# CITY OF ALBUQUERQUE

August 28, 2019

RE: **Dunkin' Donuts**  
**4208 Central SW**  
**Grading Plan Stamp Date: 7/26/19**  
**Hydrology File: K12D015D**

Grading Plan

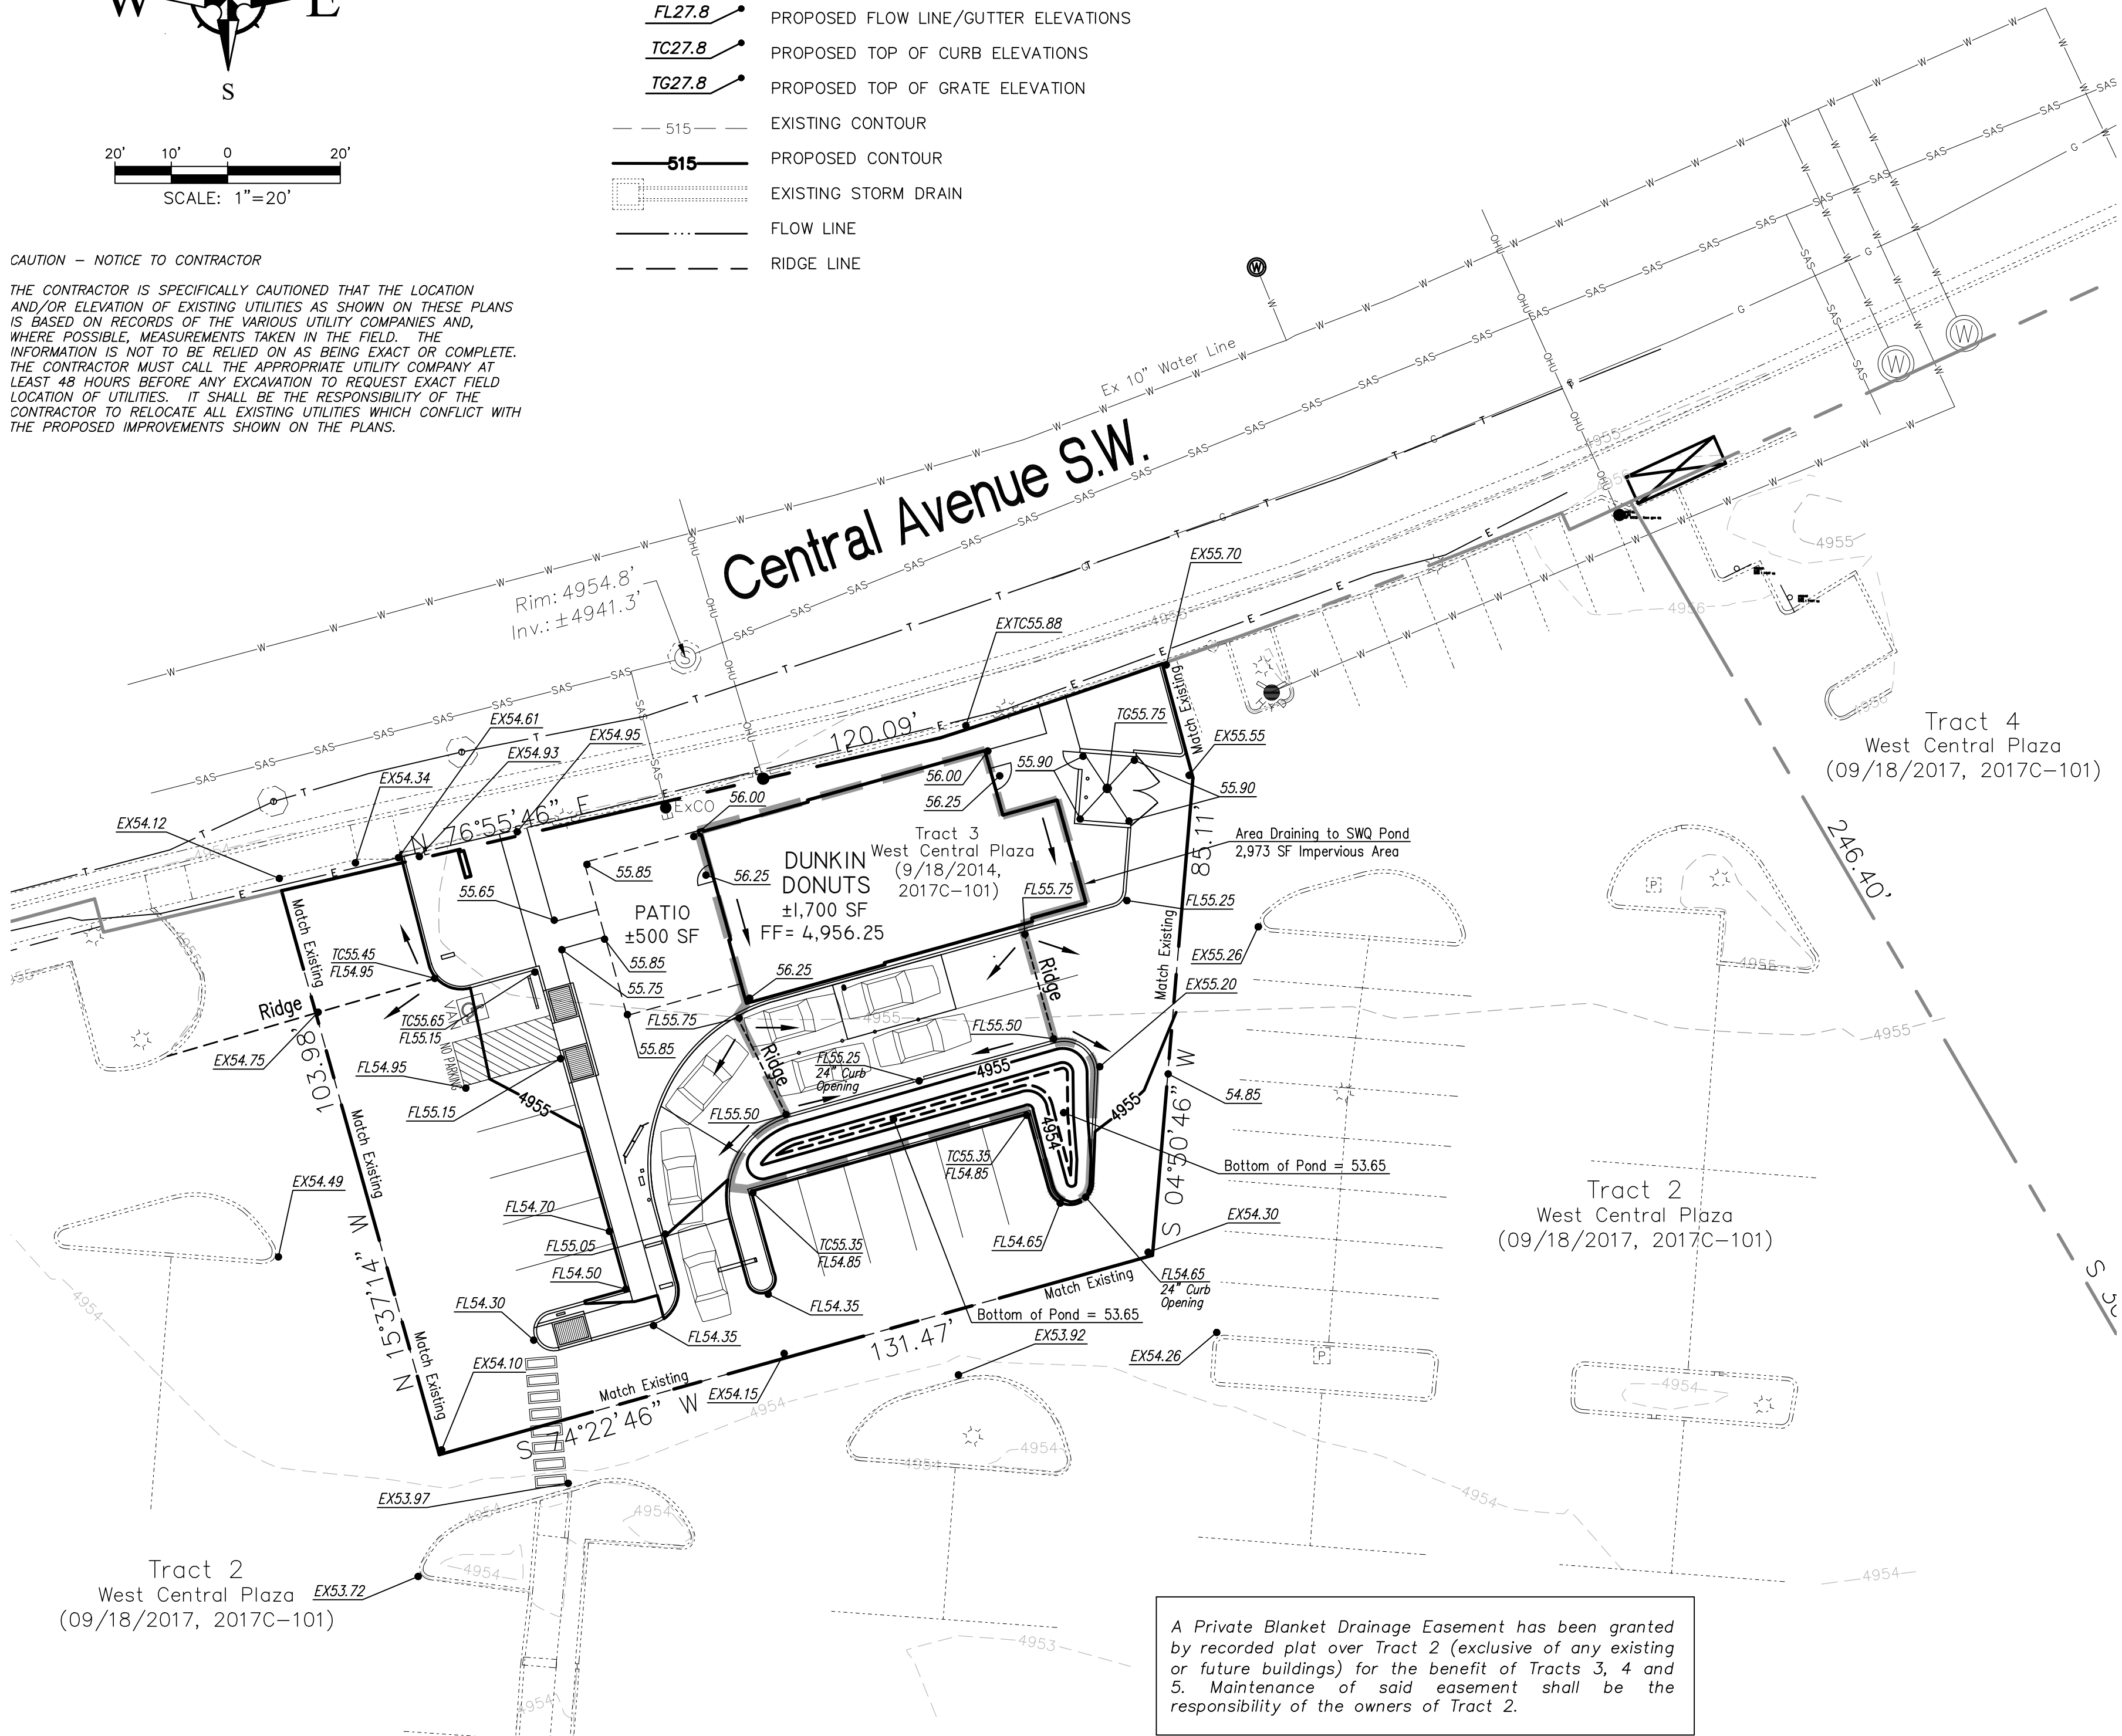
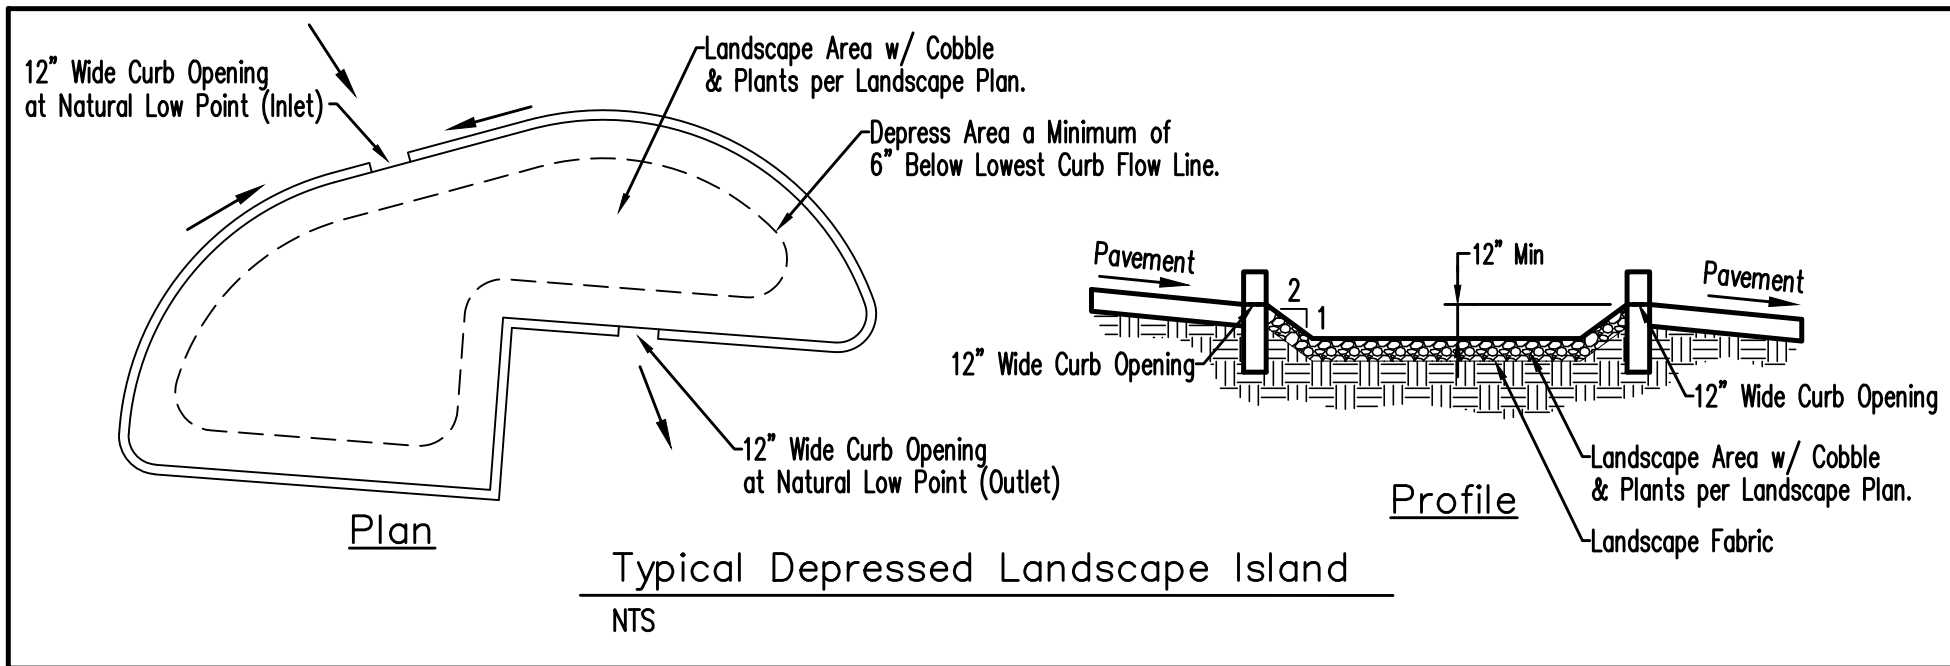
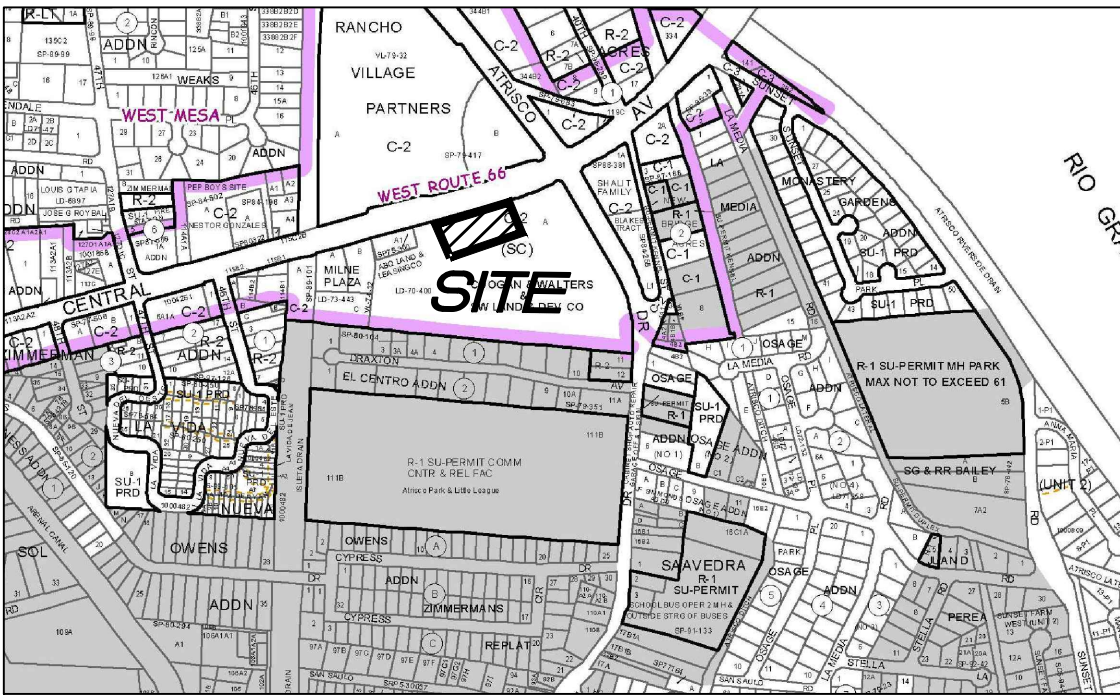
1. Payment in Lieu (Amount =  $199\text{cf} \times \$8/\text{cf} = \$1592$ , per sheet C2.1) of onsite management of the SWQ bypass volume must be made. Provide a copy of the paid receipt with a new DTIS form requesting building permit approval once paid (there is no resubmittal fee for this activity).
